### Application No. LUPL-25-0008

**Record Type : Land Use Plan**

### Document: 241010\_BLR Village C Land Use Plan.pdf

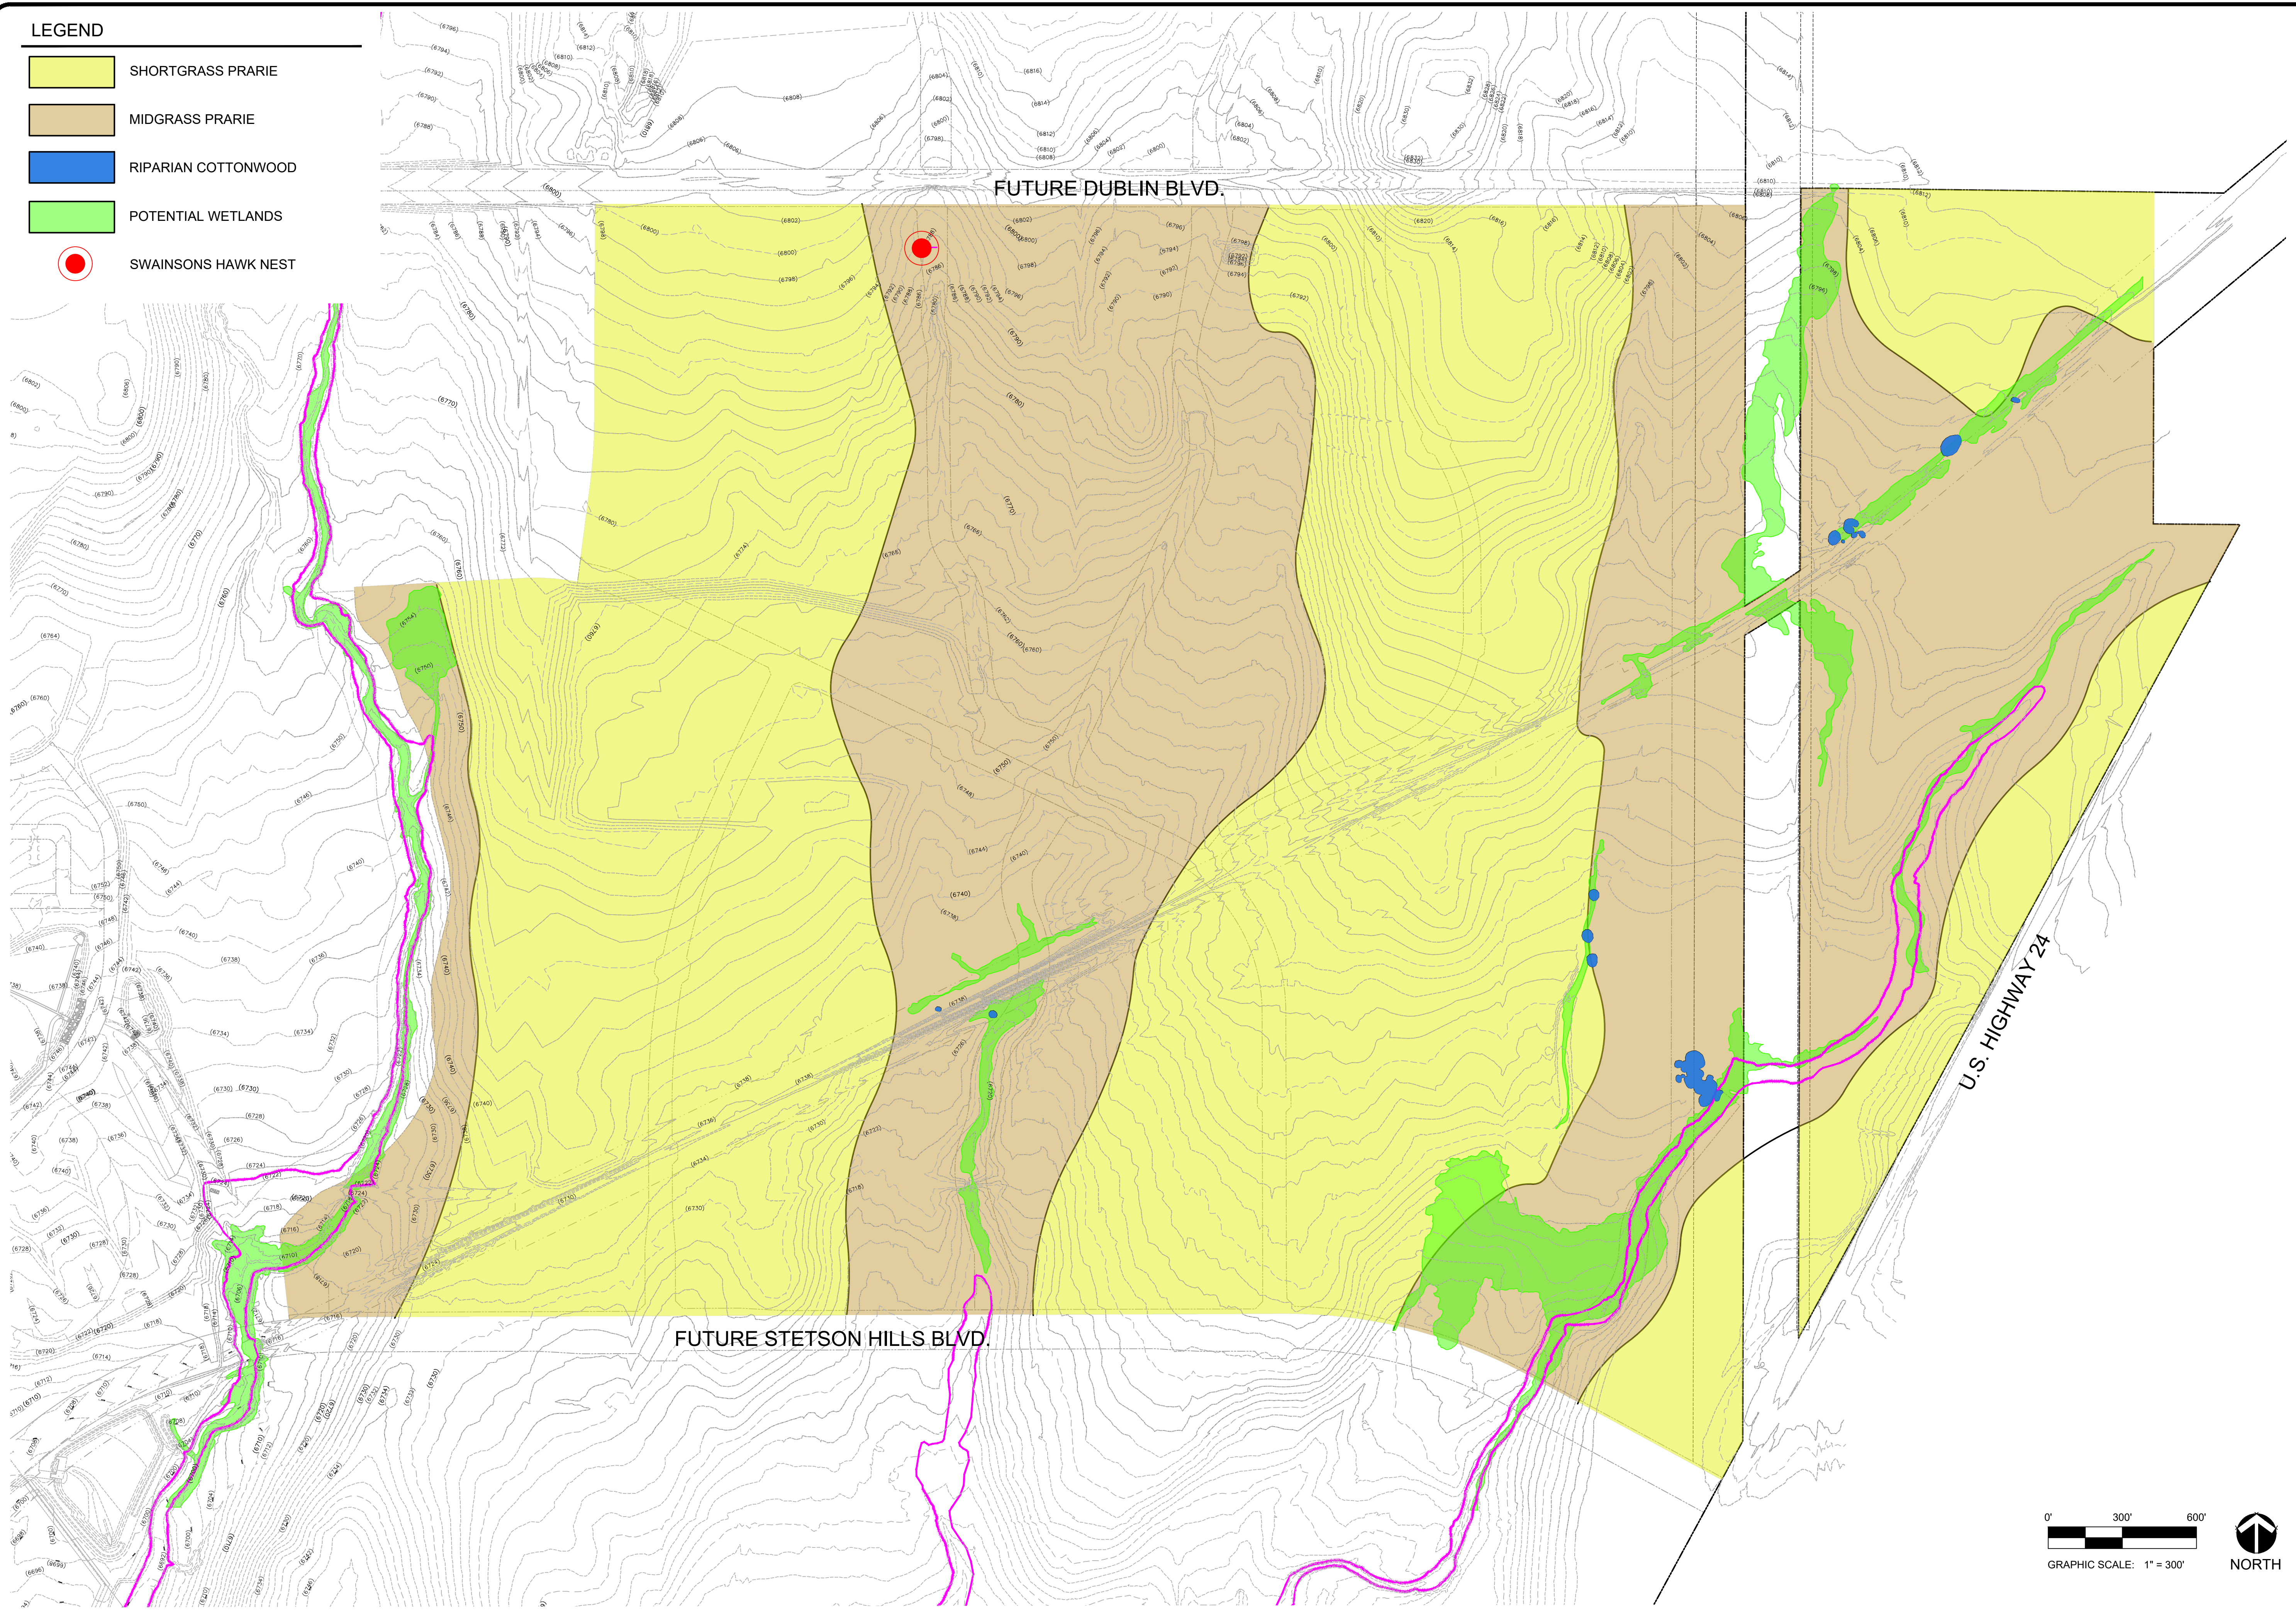
99	7	Note	Caroline Miller : Planning	Open	Not addressed: Please confirm that the potential wetlands will not pose a limitation to Community Park development over lot grading.

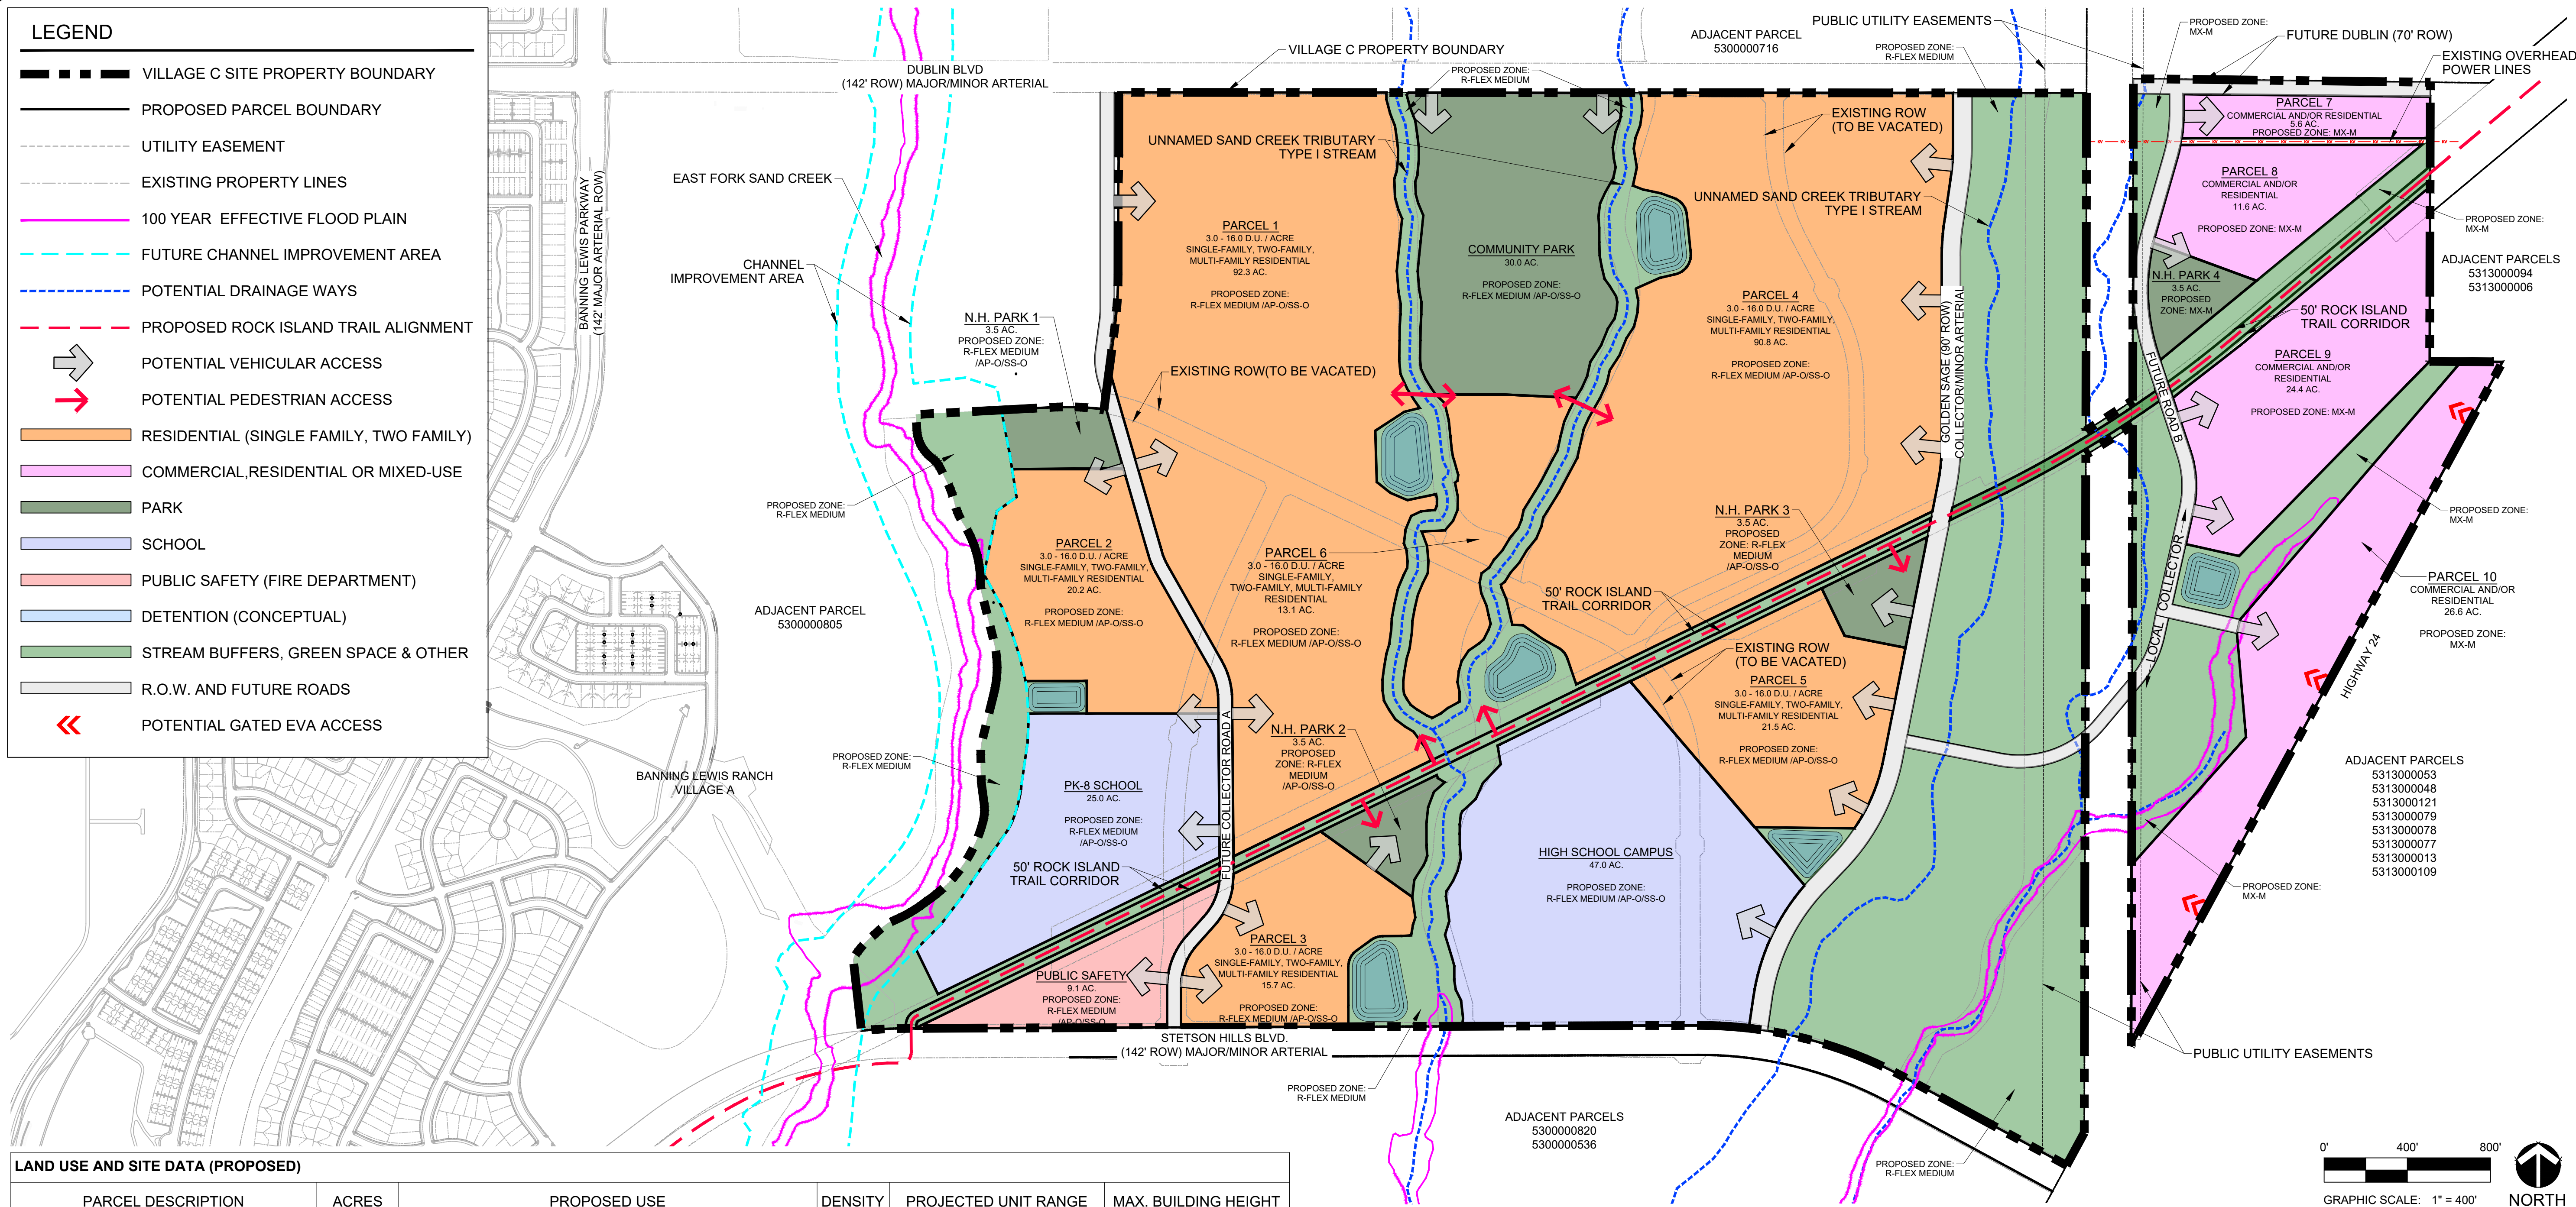
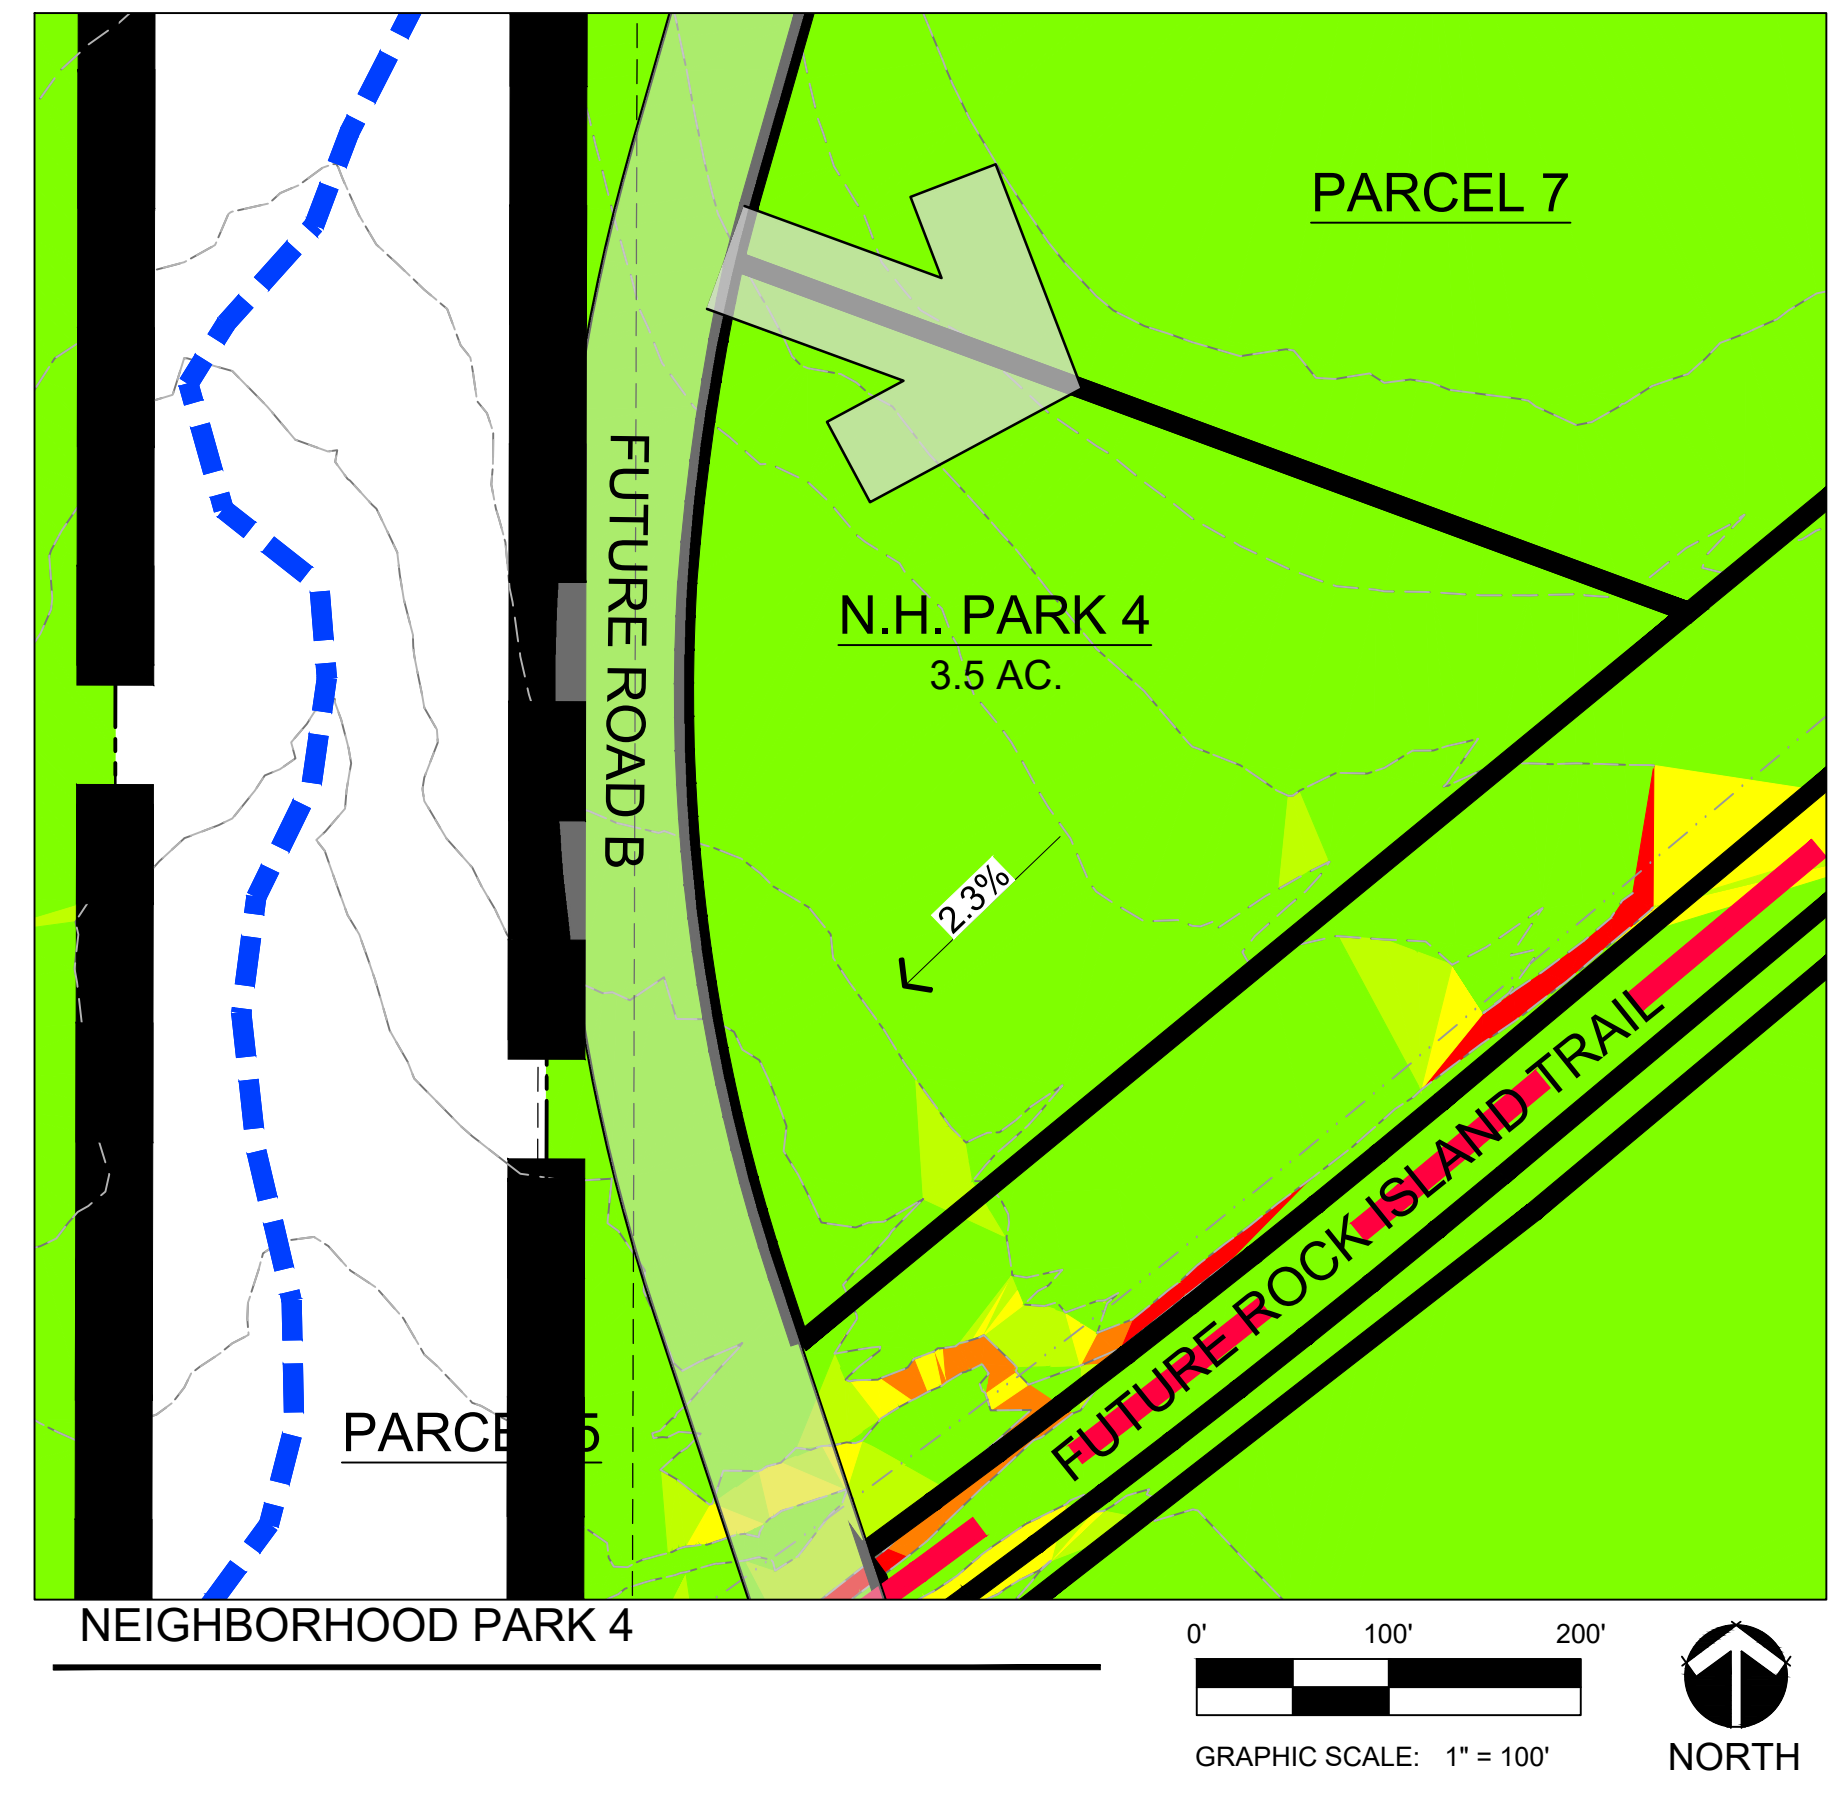
Comment ID	Page Reference	Annotation Type	Reviewer : Department	Status	Review Comments	Applicant Response Comments
82	1	Callout	Tamara Baxter : Planning	Open	verify that all the acreage match those on sheet 2	<b>Guest</b> - 11-04-2025 14:53:54  Verified and matching

Comment ID	Page Reference	Annotation Type	Reviewer : Department	Status	Review Comments	Applicant Response Comments
88	2	Callout	Tamara Baxter : Planning	Open	Will future residential in this area be limited to the 3-156 du/ac, similar to R-Flex Med?	<p>Guest - 11-05-2025 10:11:24</p> <p>Density for the MX-M has not been determined yet and is still being reviewed.</p>

25	2	Note	District #49 : School Districts	Open	PK-8 proposed	<p>Guest - 09-10-2025 09:32:21</p> <p>Updated</p>
